Equinor's application for SEP/DEP

Oulton Parish Council (OPC) response at Deadline 5

DRAWING No. PB8164-RHD-ZZ-XX-GA-R-0003 REVISION

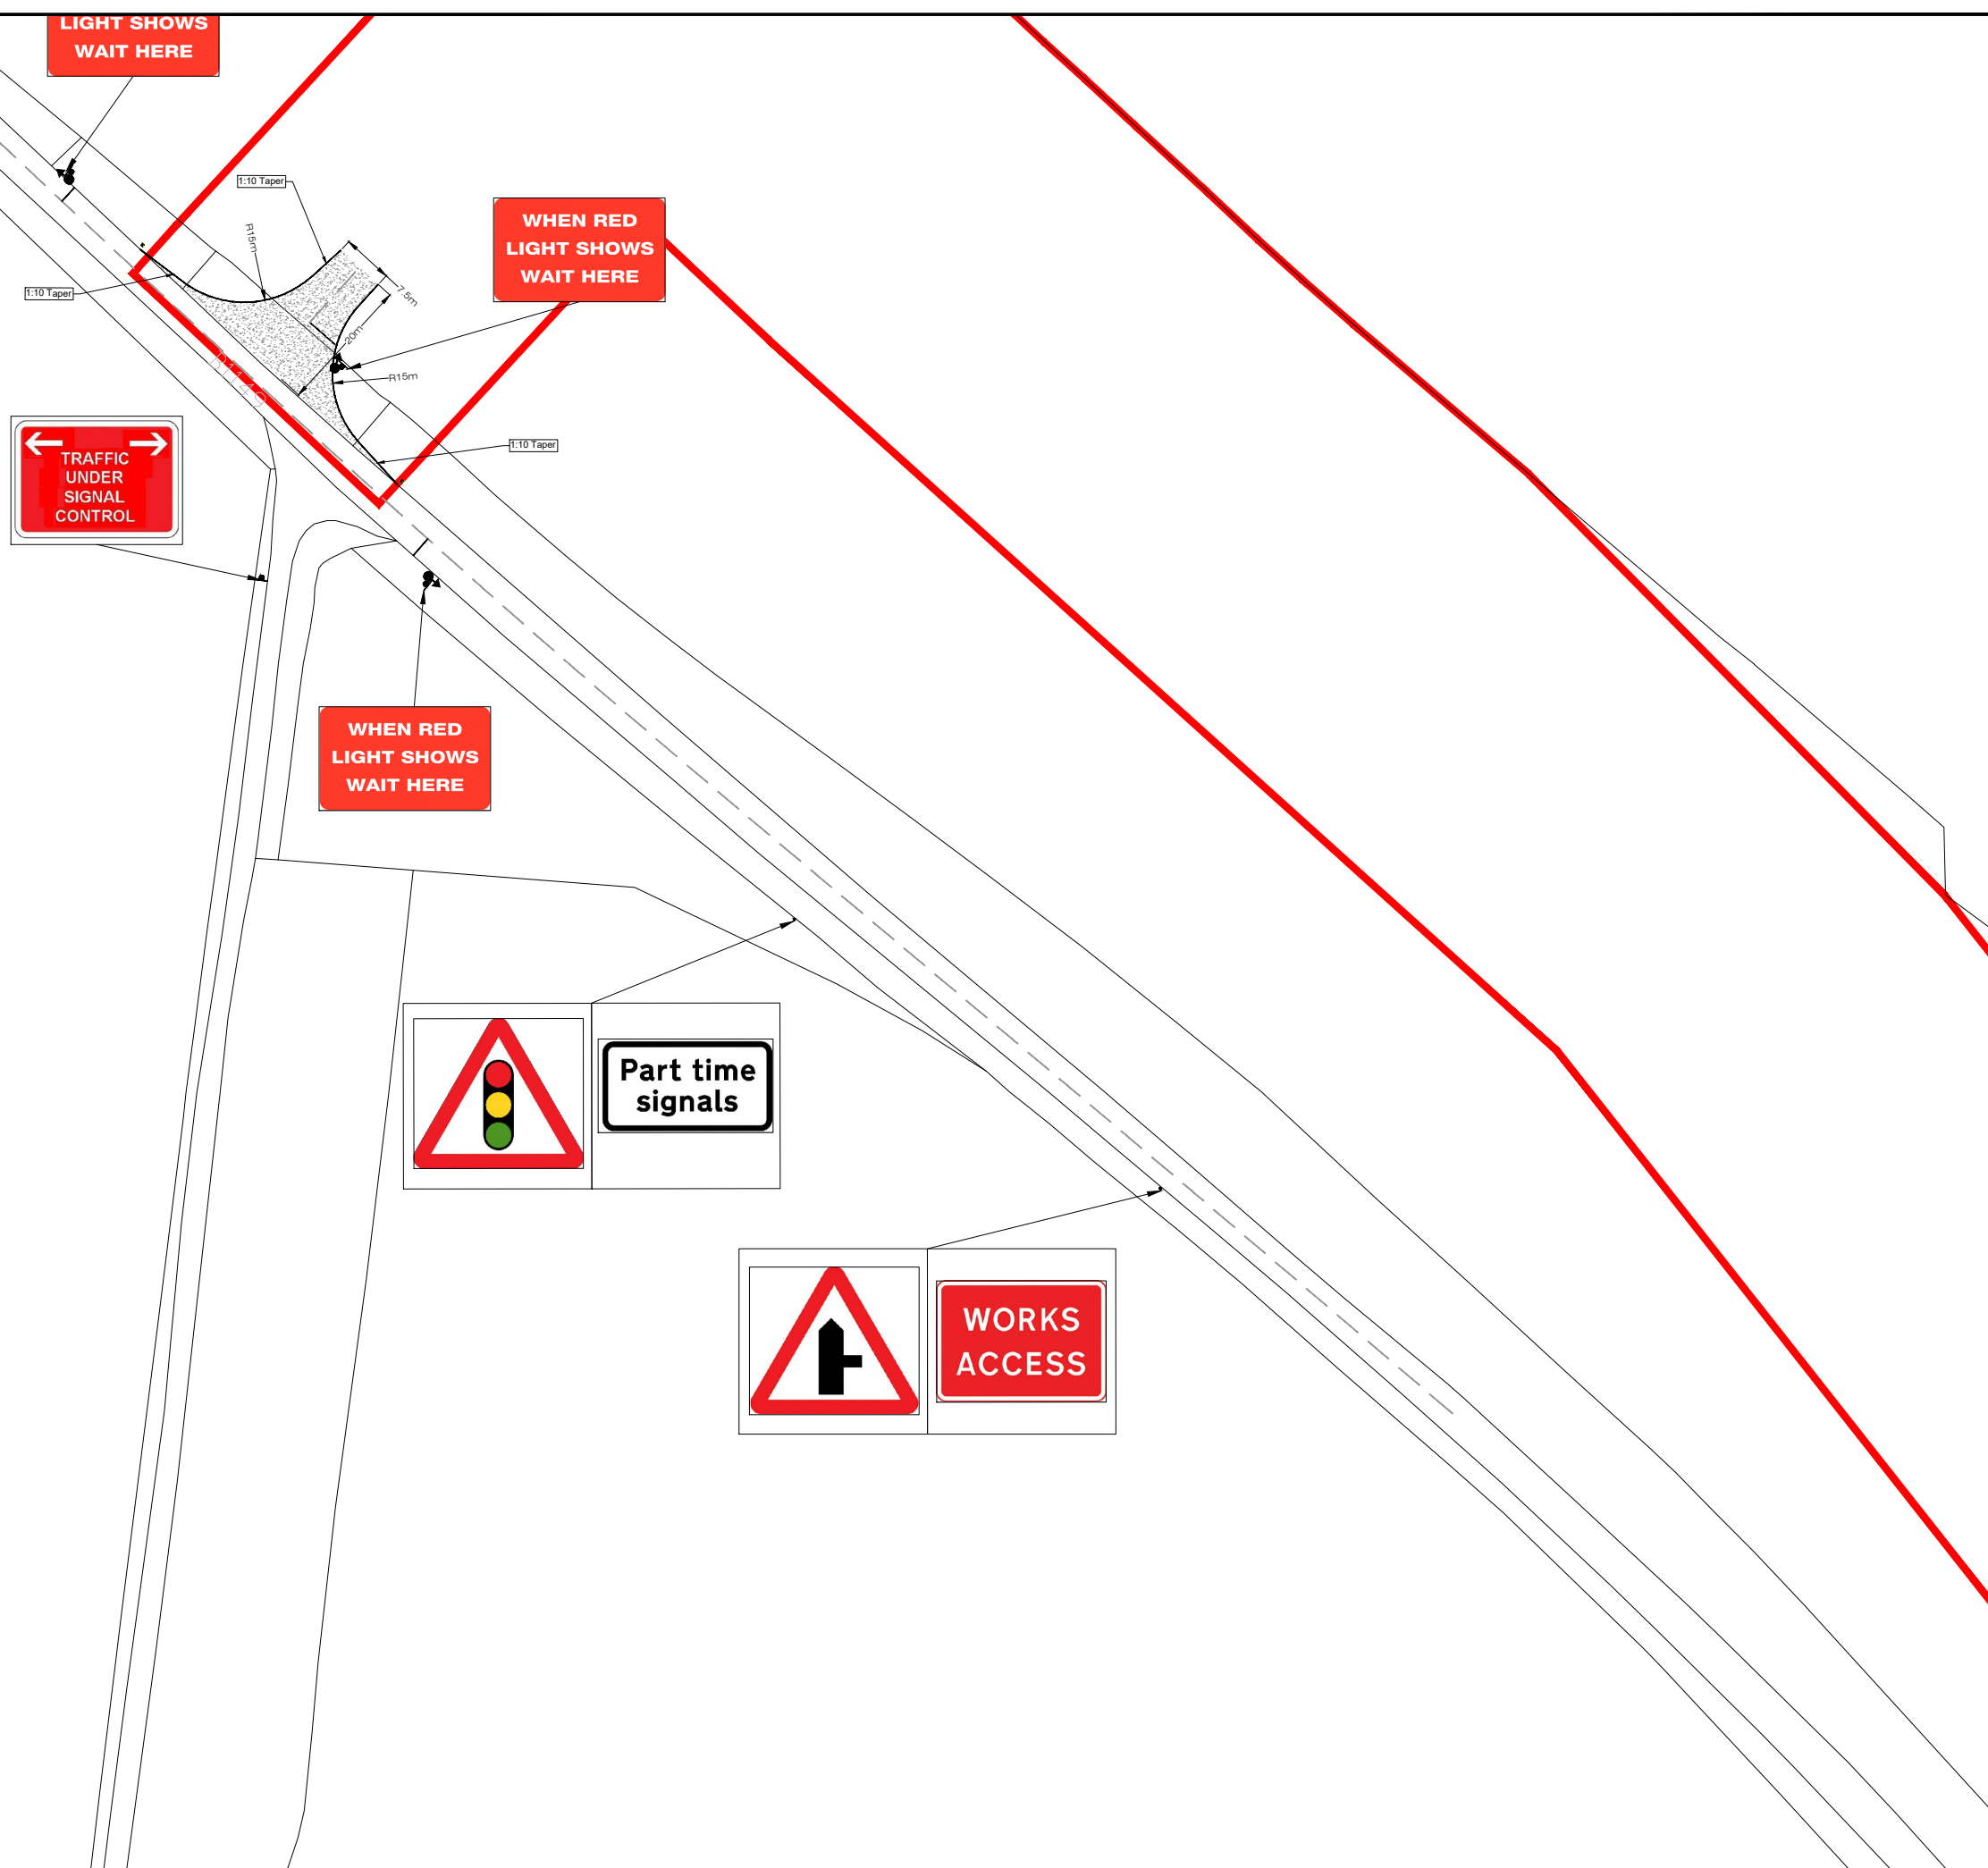
OPC have queries which relate to the proposed use of traffic signals for **ACC25 temporary compound and ACC25B cable route and HDD works.**

However, there are also plans for traffic lights at ACC25 (*pages 53-55*) which gives access to the temporary compound from B1149. The Applicant has not indicated whether ACC25 will be in operation at the same time as ACC25B. OPC would seek clarification on how the two sets of traffic lights will interact and how long the temporary compound will be needed for, and whether ACC25 traffic lights have the same restrictions as ACC25B?

OPC are unaware of this having been explained in the OCTMP. The Applicant will therefore need to explain the operational design for ACC25(temporary compound) with ACC25b (cable route/HDD), along with any cumulative impacts of traffic lights near to the junction of the B1149 with The Street and Link 131 (SEP/DEP), Link 68 (Vanguard/Boreas) Link 208 (Hornsea Three Main Construction Compound).

DRAWING No. PB8164-RHD-ZZ-XX-GA-R-0014 REVISION

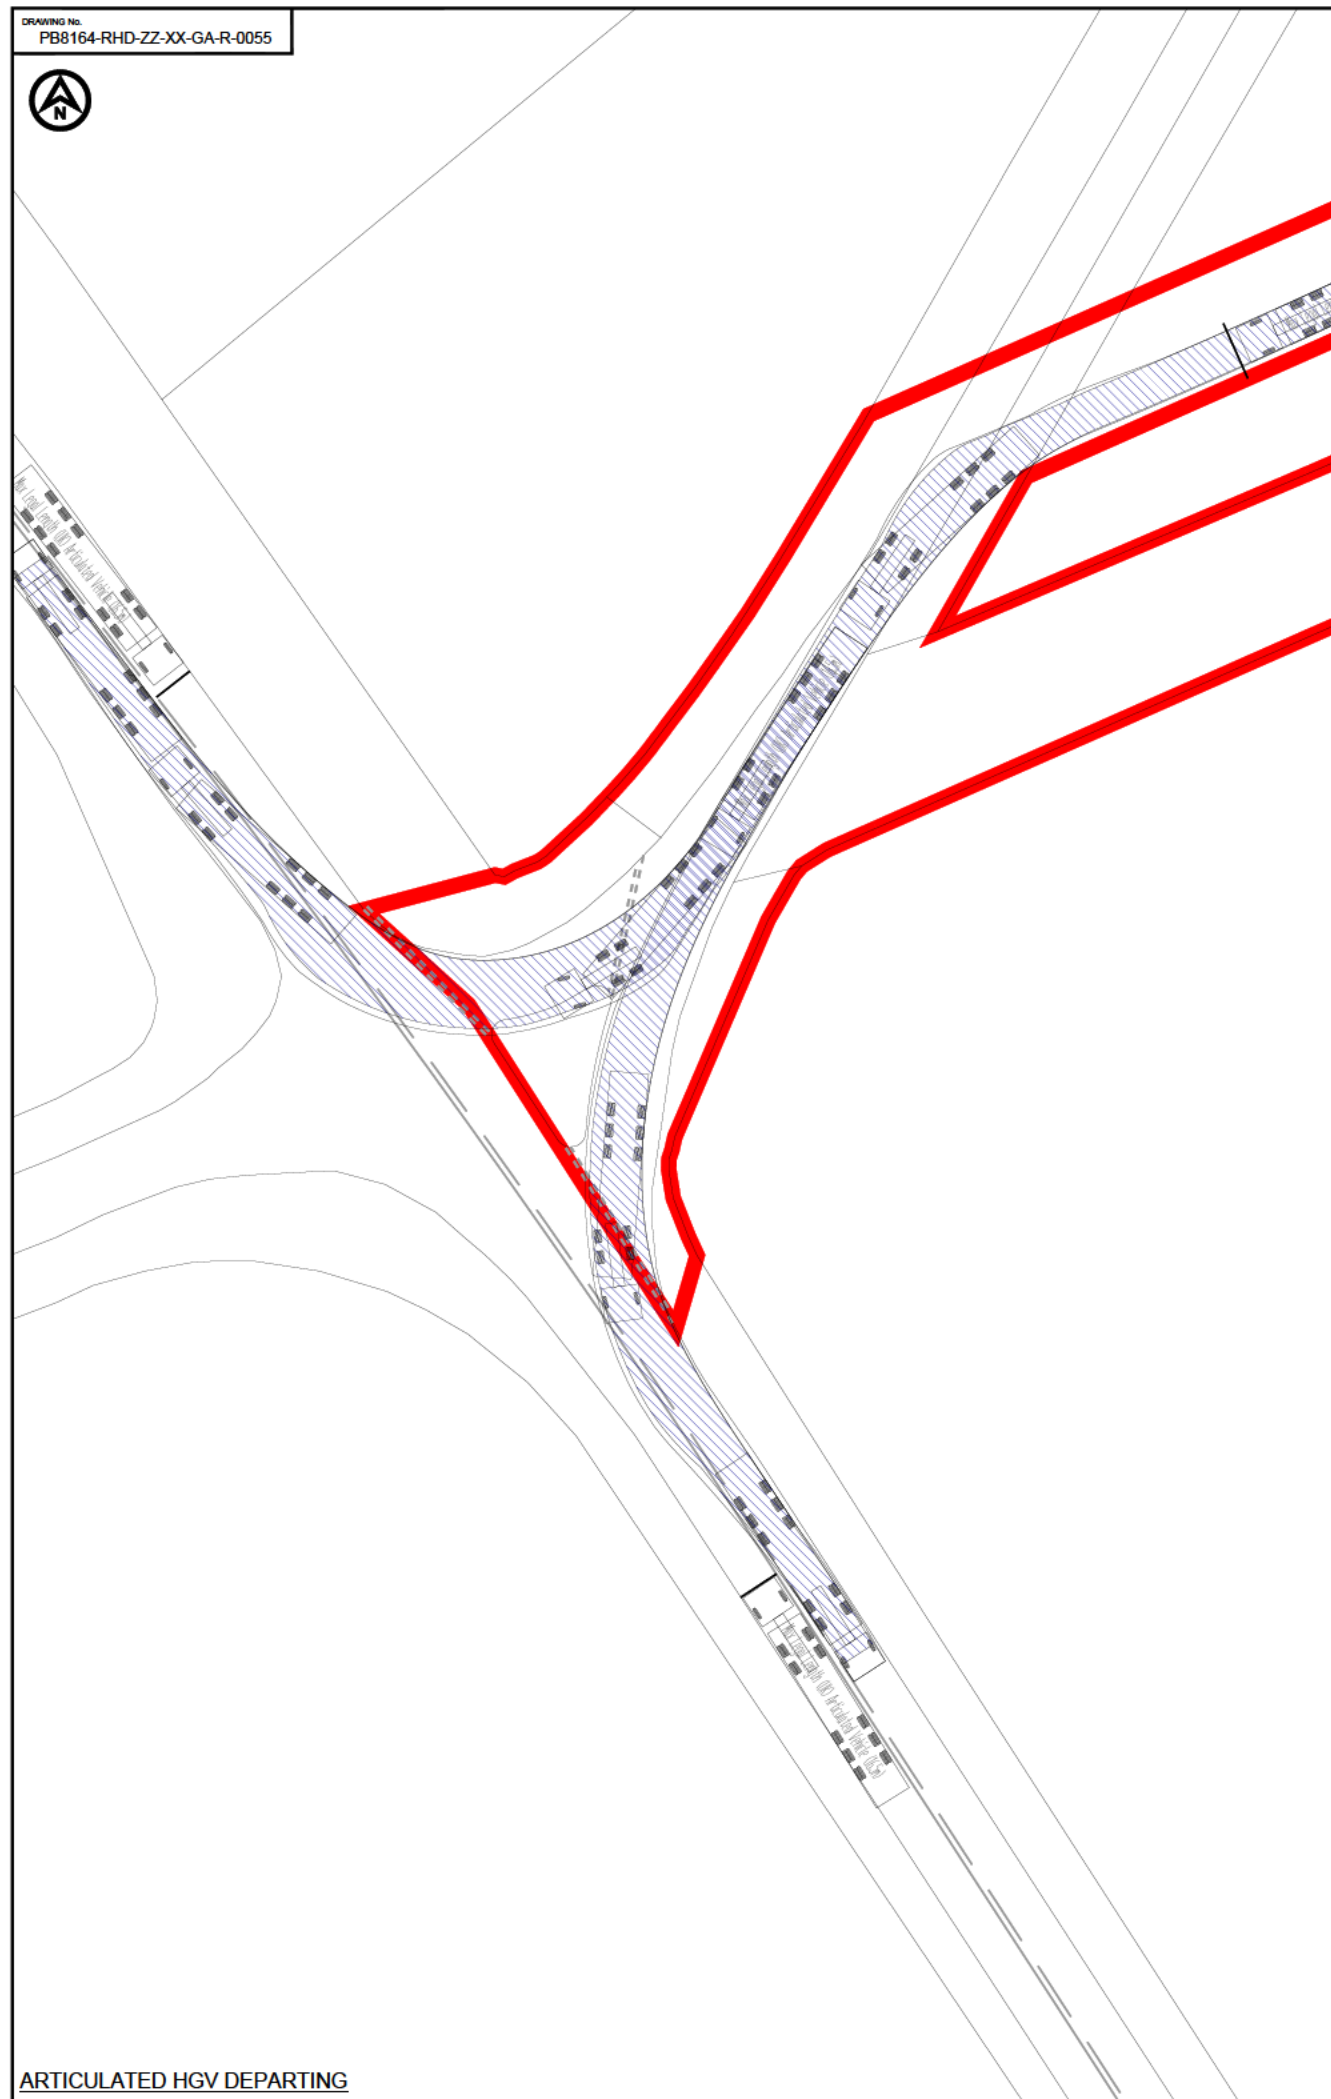
OPC note from the revised OCTMP (APP-301 revision C) submitted at Deadline 3, that there is mention of temporary traffic lights at ACC25B, along with plans (*pages 50-52*) for the traffic signalling and swept path information at this location.
